DELEGATED LISTED BUILDING DECISION

Item No.	Report of the Head of Planning & Enforcement Services		
Address	RAF NORTHOLT, SIR KEITH PARK BUILDING (BUILDING 27) WEST END ROAD RUISLIP		
Development:	Alterations to existing elevations (Application for Listed Building Consent.)		
LBH Ref Nos:	189/APP/2010/2882		
Drawing Nos:	MS 1129 Design and Access Statement Window Details and Specifications from West End Glass Homelight Windows Drawing B1 Homelight Windows Drawing Eb 010 Sheet No. 17 Homelight Windows Drawing Hw 6 Homelight Windows Drawing B13 Homelight Windows Drawing Eb 010 Sheet No. 22		
Date Plans Received:	14/12/2010	Date(s) of Amendment(s):	15/12/2010
Date Application Valid:	24/01/2011		24/02/2011

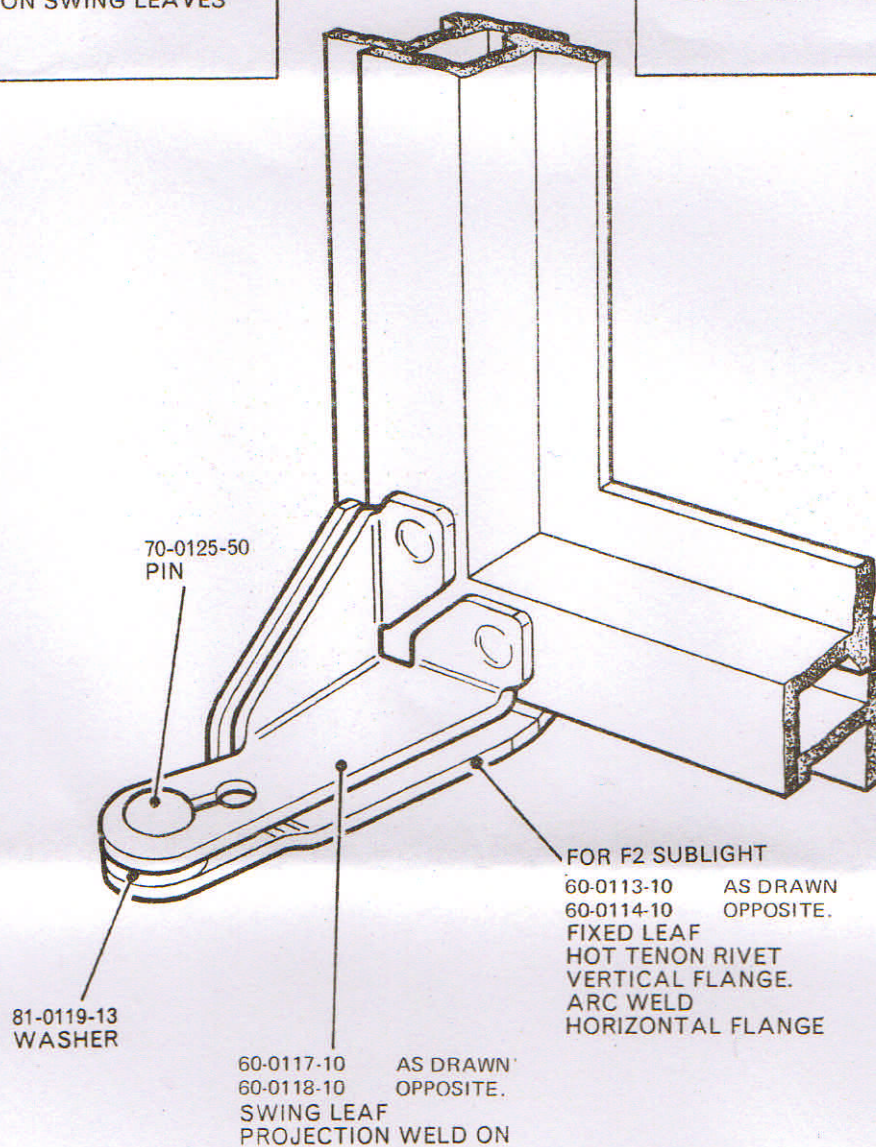
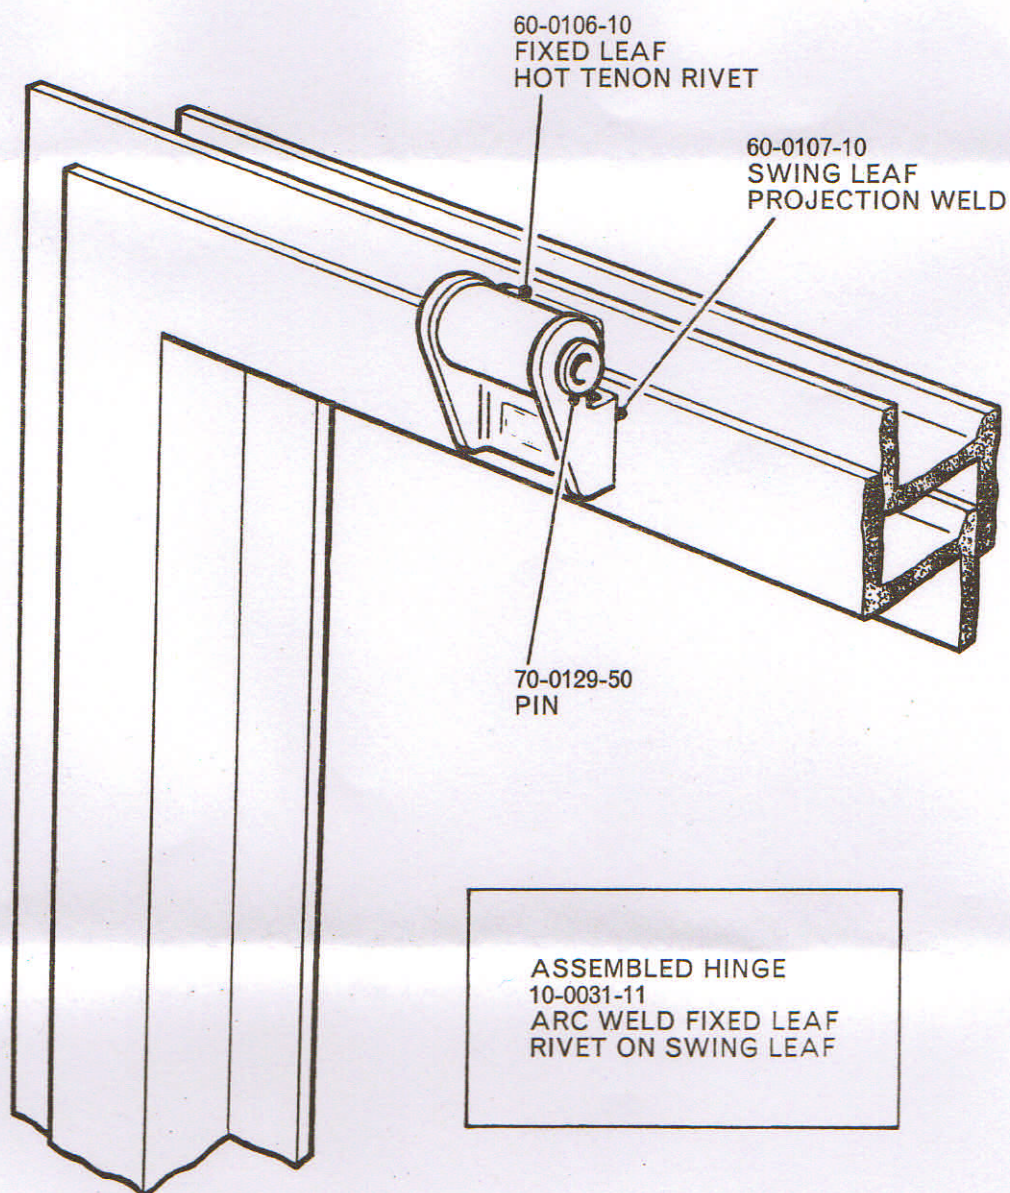
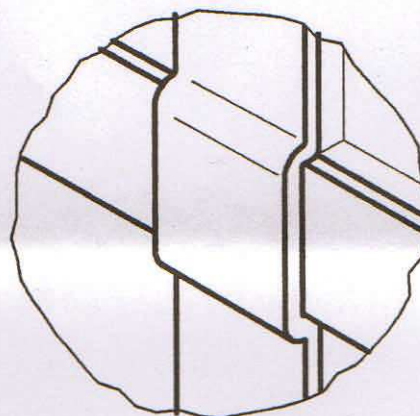
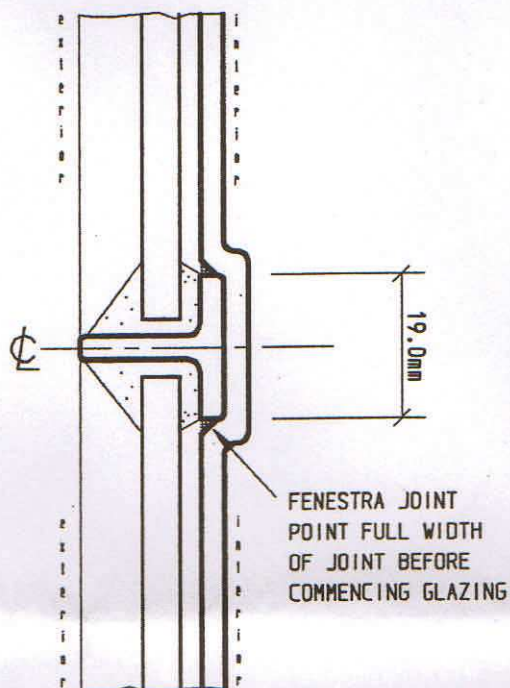
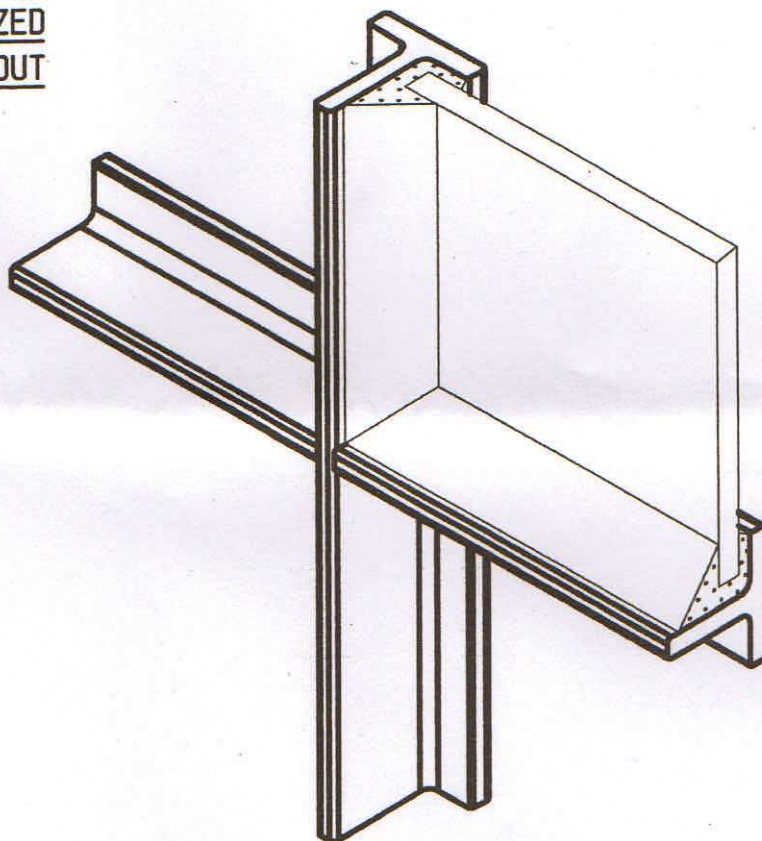
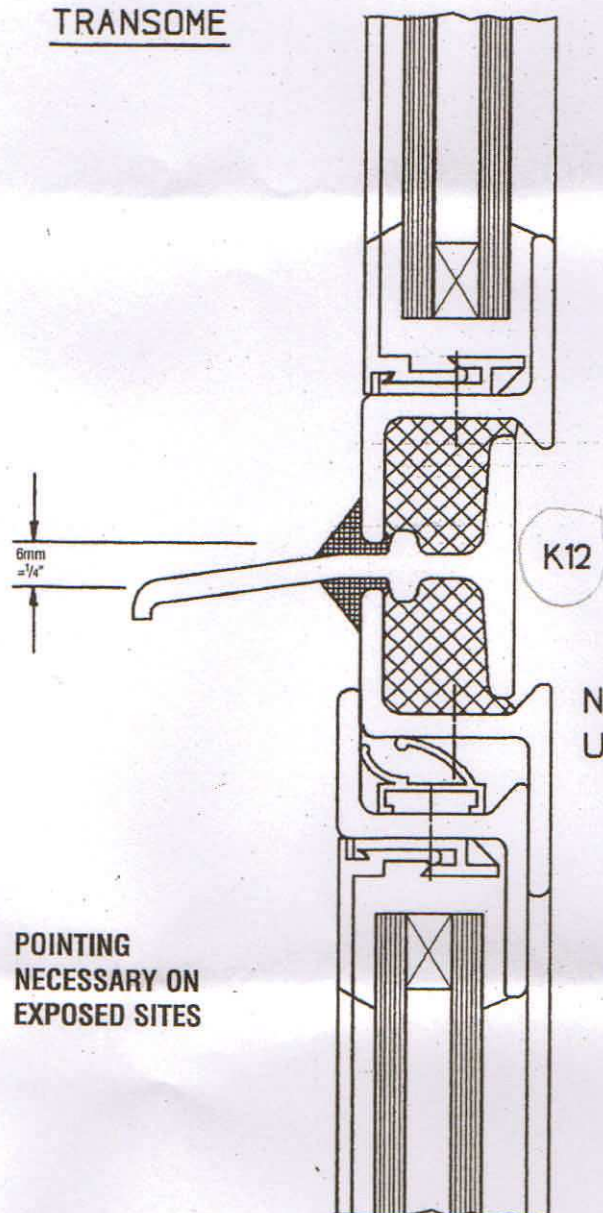
- Marked up elevational drawings, or if these cannot be provided, photographs, which show the existing windows and which also indicate the type of replacement window for each location- these must concur with the numbers for each type included in the Crittal window schedule
- A detailed window construction drawing to scale, this may be generic in this instance, given the sketch drawings already provided by Crittal.
- Details of the proposed secondary glazing

Whilst there is no objection in principle to these works, the drawings are insufficient to take this matter forward at present; revisions and further information are required at this stage.

The proposals and together with the photos and marked up floor plan are acceptable. One or two of the window photos are missing, but it is clear what is being proposed for these from the floor plan and cross reference with the window manufacturers schedule.
